15th September 2022

OBJECTION

Application Ref: 22/01109/FUL, High Ridge, Top Street, Askham, NG22 0RP

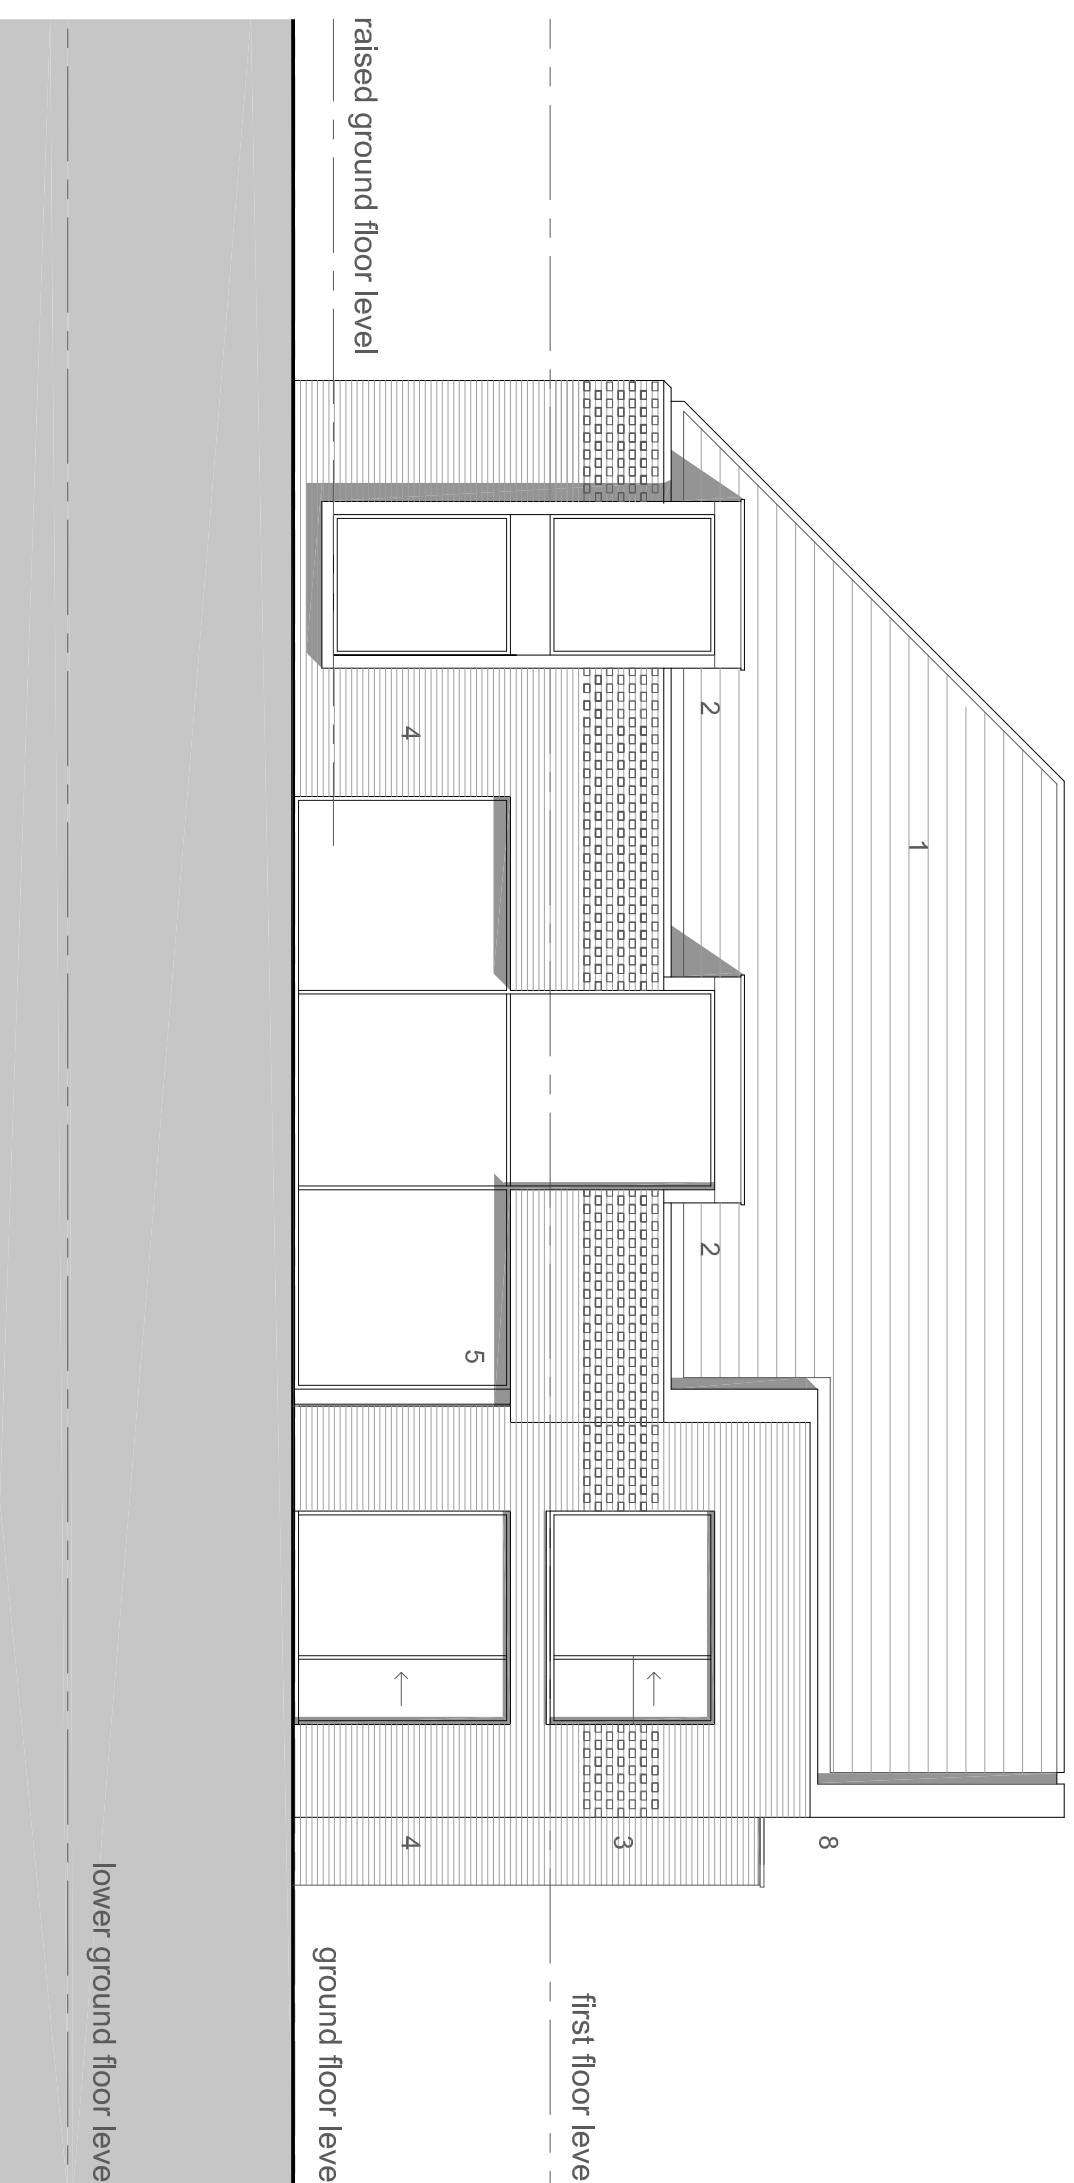
The materials proposed are of high quality, intended to reflect the local architecture and there are details which can be seen in local buildings. The scale of the development and the proportions of glass and brick do not relate to local character. This amounts to a pastiche. A large modern building has had some design elements from local architecture included without altering the fact that it is a massive construction using large areas of glass.

Height and Massing study in relation to neighbouring houses

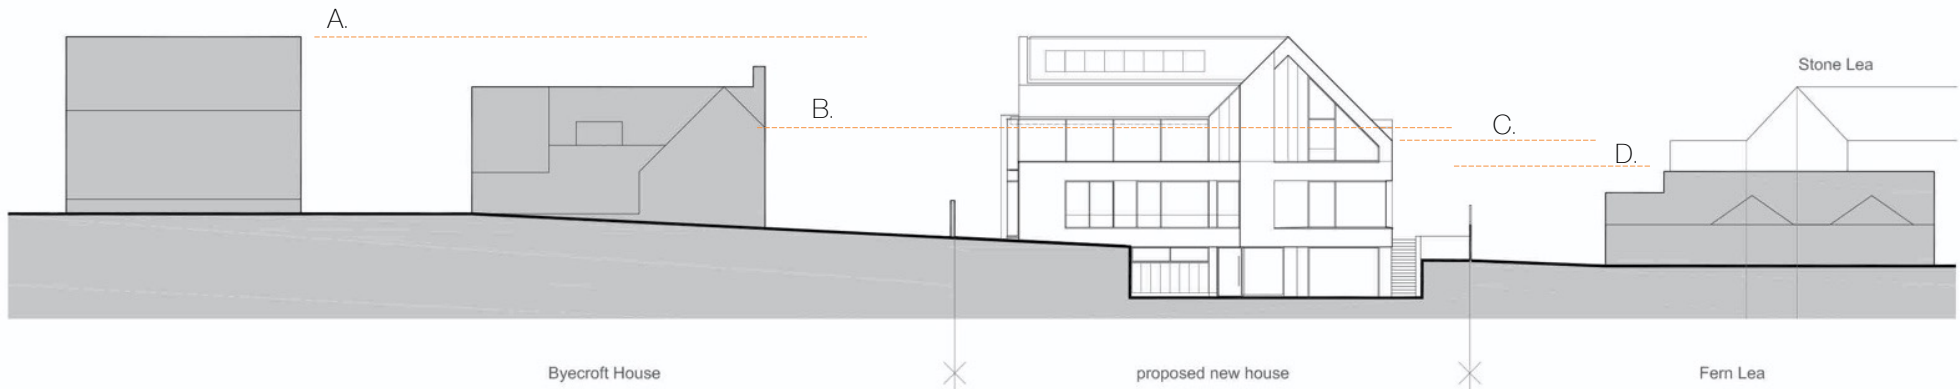
The proposed build is out of scale with the neighbouring properties. The design of three storeys requires a ridge height that has been aligned with that of the house at the top of the hill. The natural fall in the land of Top Street is currently followed by the roof lines. This natural and pleasing line can clearly be seen from our bedroom window. The higher ridge line of the proposal does not take into account the local topography. In fact there is no proper topographical analysis. Viewed from our direction there will be a jarring effect in the ridge lines, this will be much greater when viewed from the front. Page 9 of the Parish Presentation 13.09.22 clearly shows how the new house dominates, and is out of scale with Byecroft House, itself quite a large building. The buildings further down are smaller and therefore even more overpowered.
